Reviewed for Code Compliance
Inspections Division
Approved with Conditions

Address/Location of Construction: <u>23 SHEPHERD STREET</u>			Date: <u>10/21/14</u>
Total Square Footage of Proposed Structure: <u>FOOTPRINT 780 FT²</u>			
Tax Assessor's Chart, Block & Lot Chart# Block# Lot#	Applicant Name: <u>LISA BERRY</u> Address <u>23 SHEPHERD STREET</u> City, State & Zip <u>PORTLAND ME 04103</u>	Telephone: <u>450-0353</u> Email: <u>elleberry73@hotmail.com</u>	
Lessee/Owner Name : (if different than applicant) <u>N/A</u> Address: City, State & Zip: Telephone E-mail:	Contractor Name: <u>PRO GARAGE MAINE</u> (if different from Applicant) <u>RICK EASTMAN</u> Address: <u>1059 PRESOTT STREET</u> City, State & Zip: <u>MANCHESTER ME</u> Telephone <u>207.319.4590</u> E-mail: <u>PROPARGEMAINE.COM</u>	Cost Of Work: \$ <u>29,200</u> C of O Fee: \$ _____ Historic Rev \$ <u>0</u> Total Fees : \$ _____	
Current use (i.e. single family) <u>SINGLE FAMILY</u> If vacant, what was the previous use? <u>N/A</u> Proposed Specific use: <u>SINGLE FAMILY</u> Is property part of a subdivision? <u>NO</u> If yes, please name _____ Project description: <u>GARAGE ADDITION WITH MUDROOM AND BONUS ROOM OVER GARAGE</u>

**FIRST FLOOR PLAN**  
 $\frac{1}{8}'' = 1'-0''$

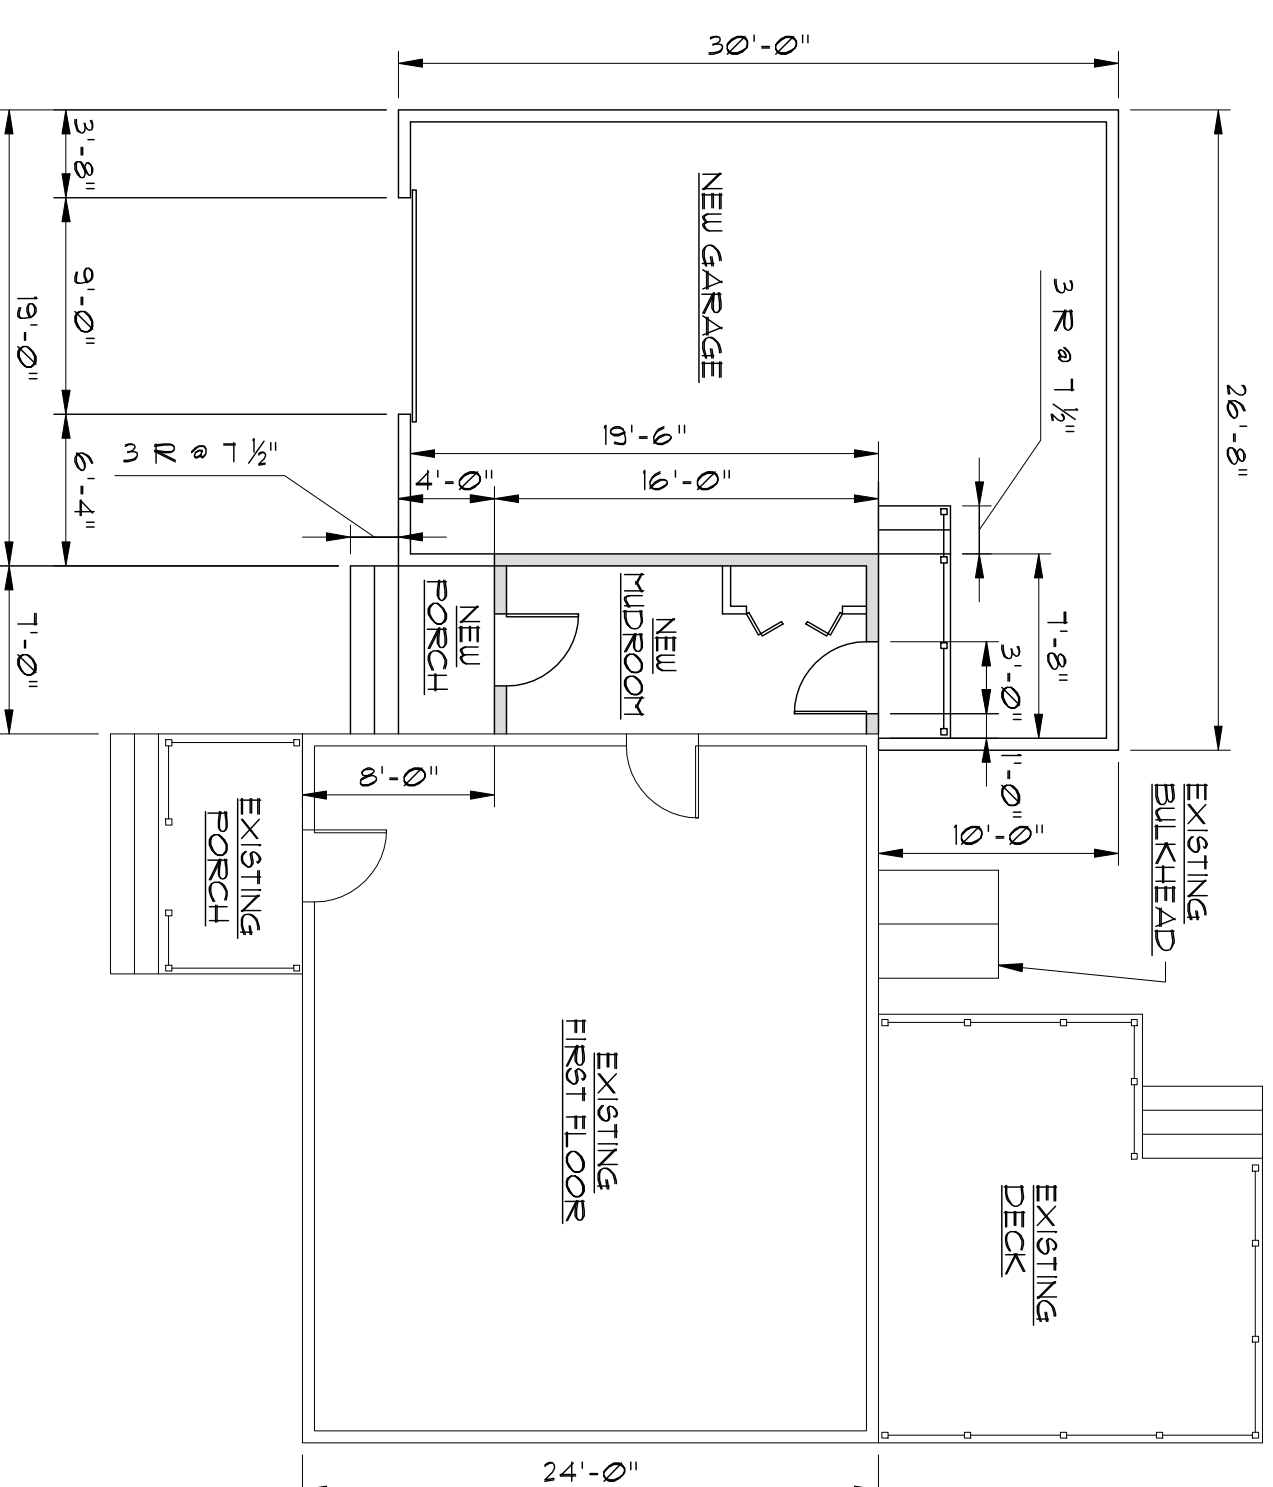
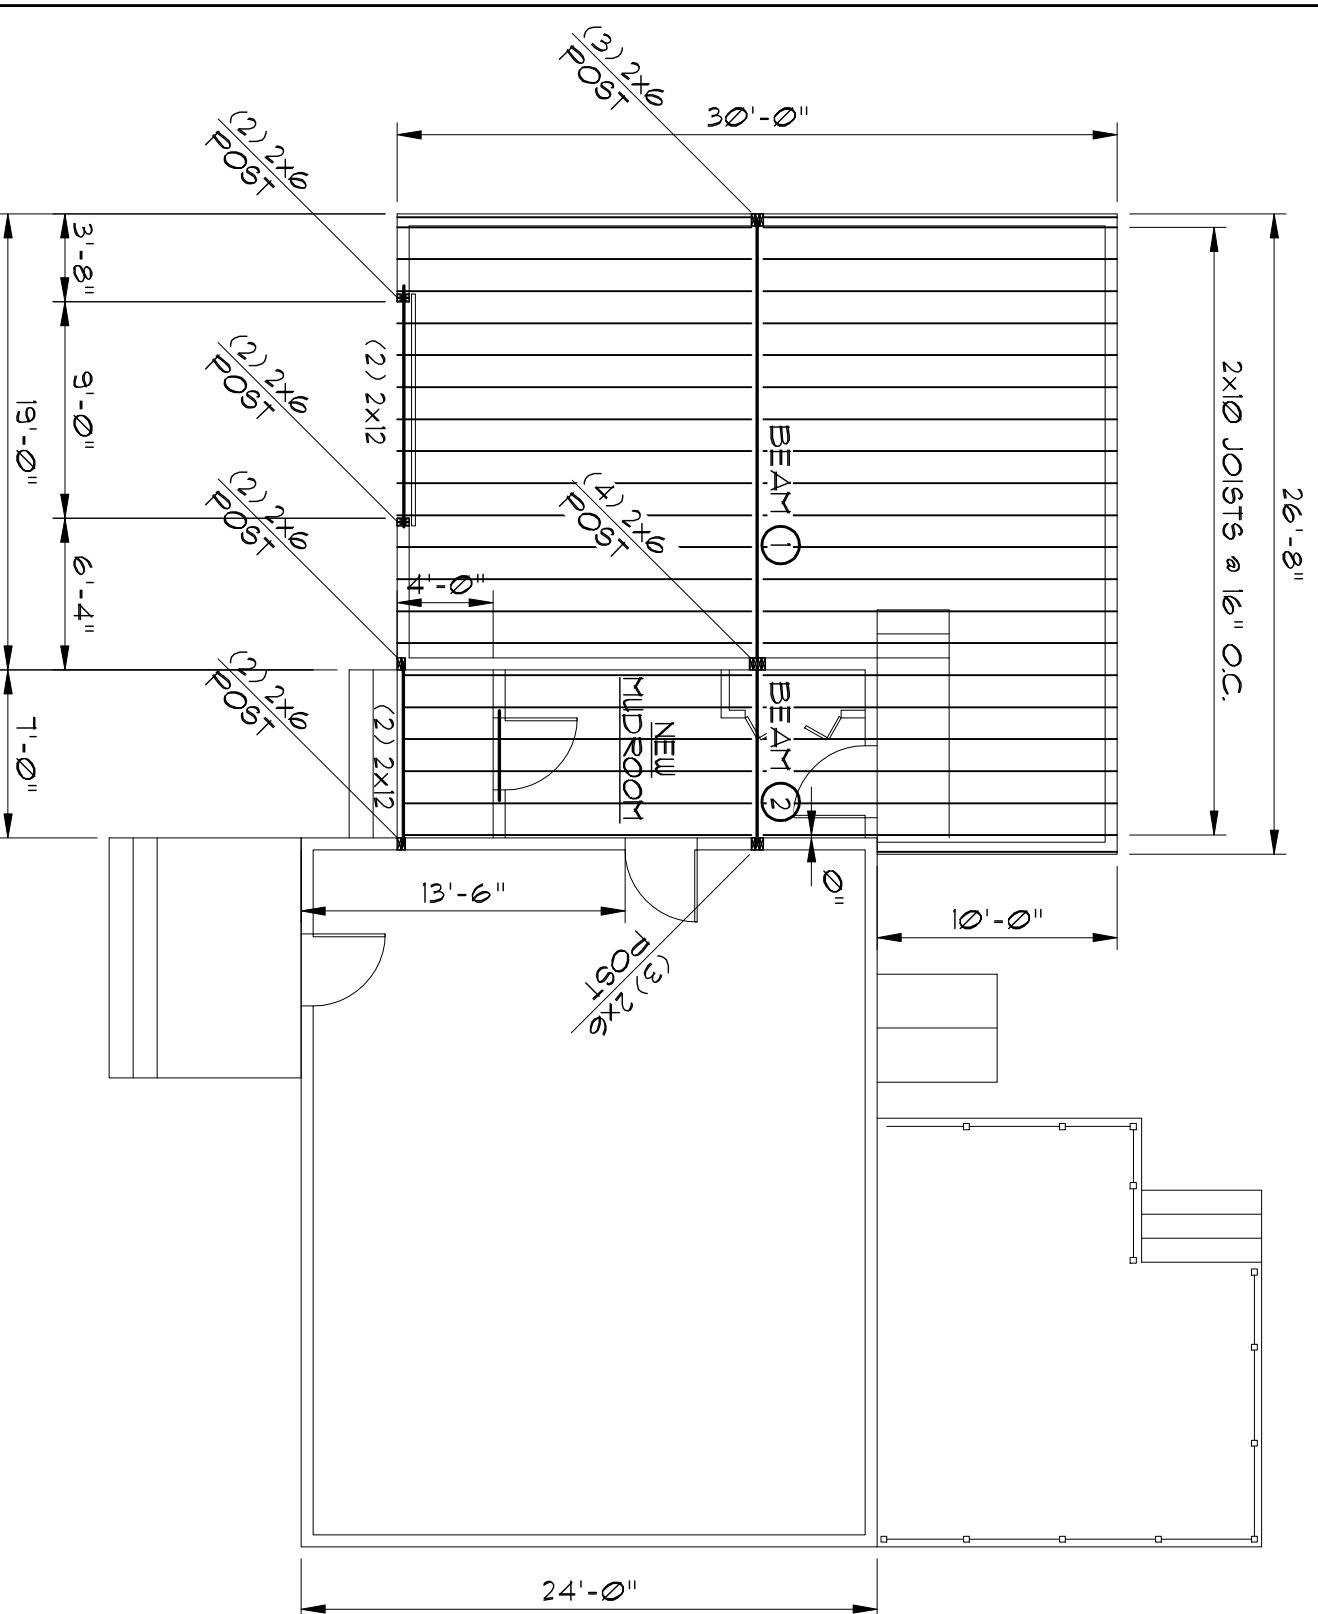
New stairs must have a minimum of a 10" tread and 7-3/4" rise. Please see your conditions of your permit.
